PROJECT NAME: The Bay House Phase 2

PROJECT DESCRIPTION:
39 Unit, Four Story Residential Multi - Plex

Level III Site Plan Application
Seaport Lofts: Submittal No. 4

Level III Site Plan Application
Seaport Lofts: Submittal No. 6

Drawing file: 10_3_13_revised submittal / City Submittal 5.3 - Sheet 4 Subdivision Plat.PDF

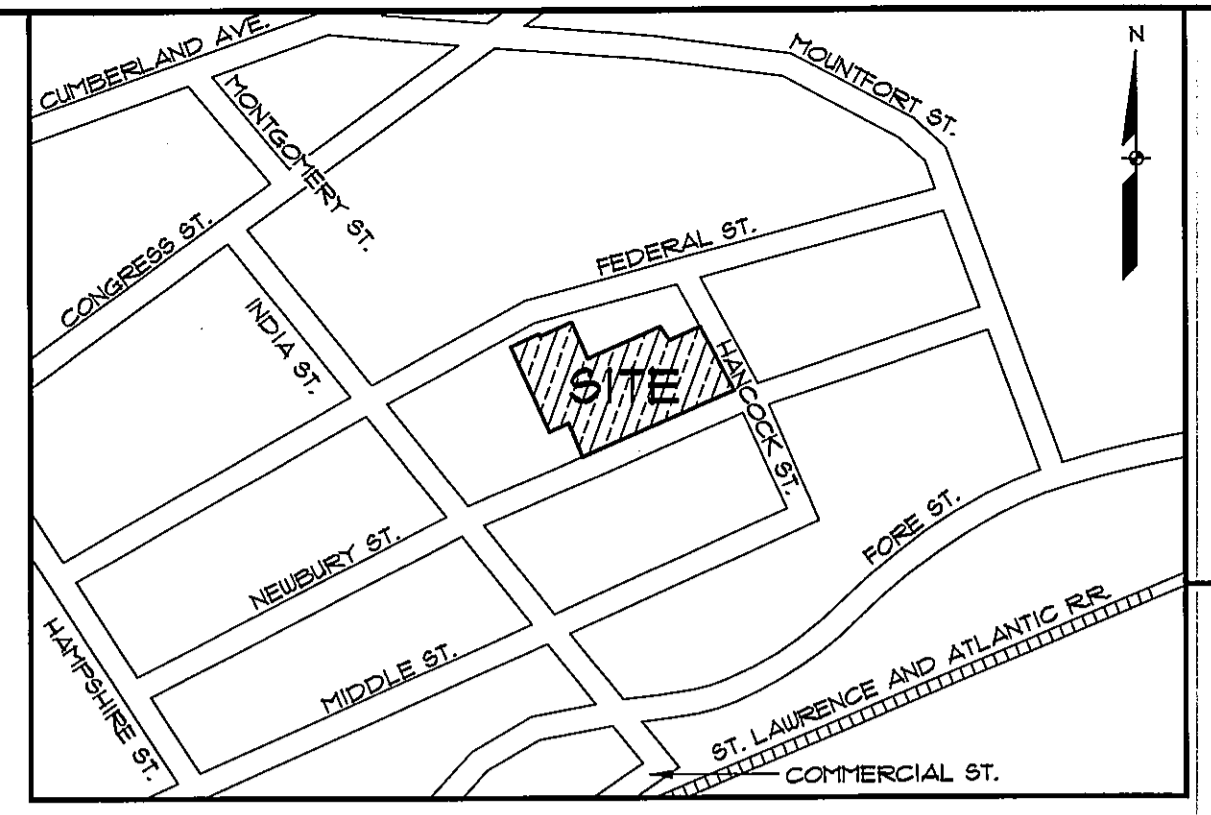
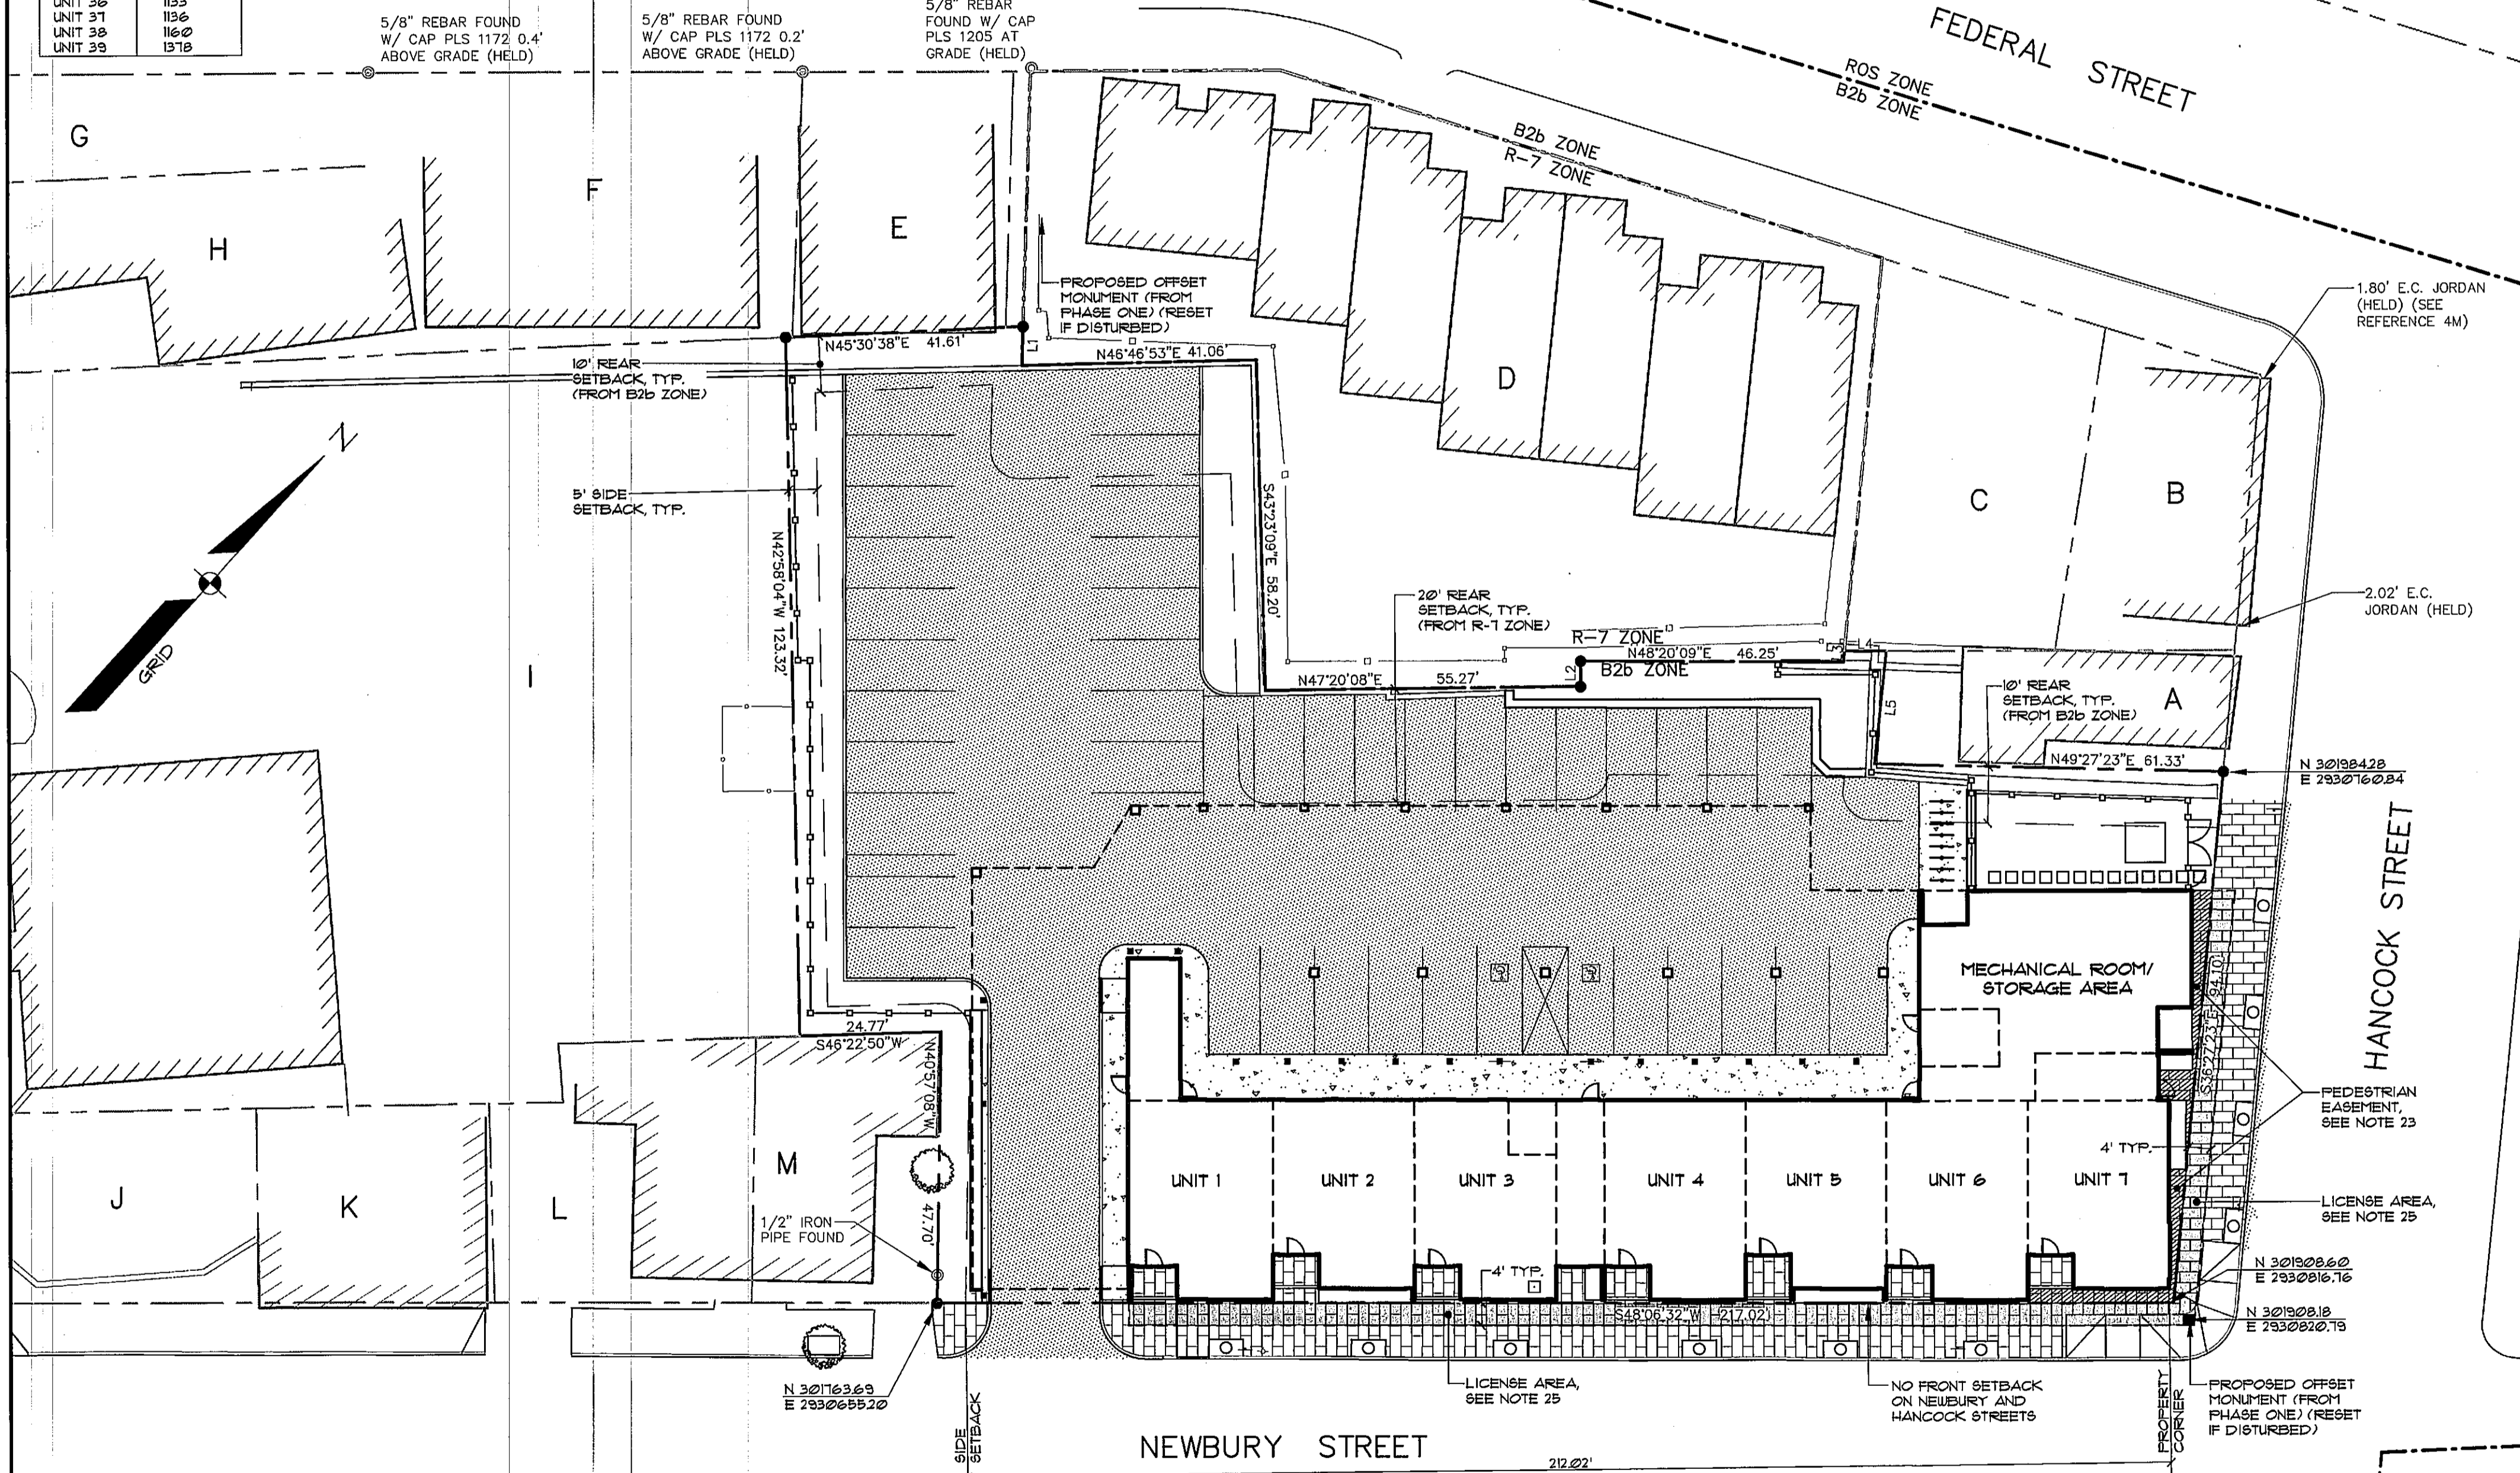
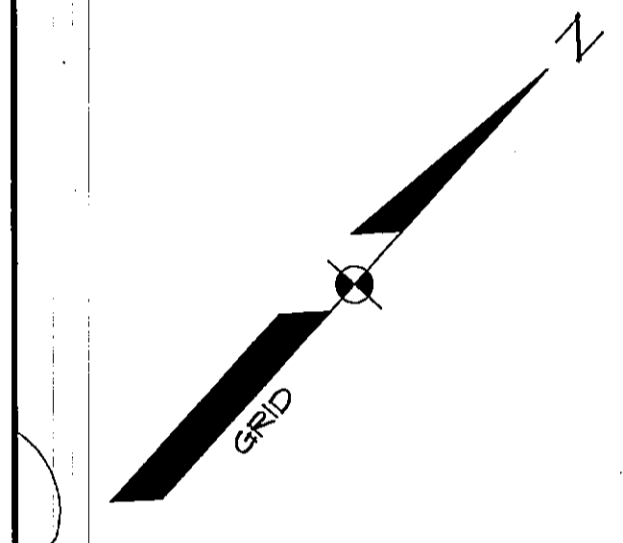
1. We understand that David Senus and Marge Schmuckl are satisfied with prior responses and have no further comments.
- 2a). The site drawings have been updated to reflect changes to the building footprint and canopies.
- 2b). We added a note on the Site Plan that the townhouse entries will be illuminated "with details to be provided to the City per conditions of approval".
- 2c). We have selected a more contemporary, less ornate wall mounting bracket for light fixtures – see Revised Attachment T- Lighting Cut Sheets.
- 2d). Note # 23 on the Subdivision Plat has been revised as requested.
- 2e). The stormtech/ subsurface detention system has been added to the Subdivision Plat as requested.

- 5.1). We added a note on the Subdivision Plat regarding the responsibility of maintaining the retaining walls, as requested.
 - 5.2). The invert elevations of the pipes noted have been revised as requested.

- 5.3). The catch basin sump is now shown as 3' and the notes pertaining to the drain manholes have been added, as requested.
 - 5.4). We removed the extraneous text near Line L1 on the Subdivision Plat.

- 5.5). We added a note to the Subdivision Plat regarding the ownership of retaining walls at the northwest corner of the site, as requested.
- 6). We revised the note regarding the street monument as requested.

- 7). We enlarged the text boxes on the Subdivision Plat as requested.
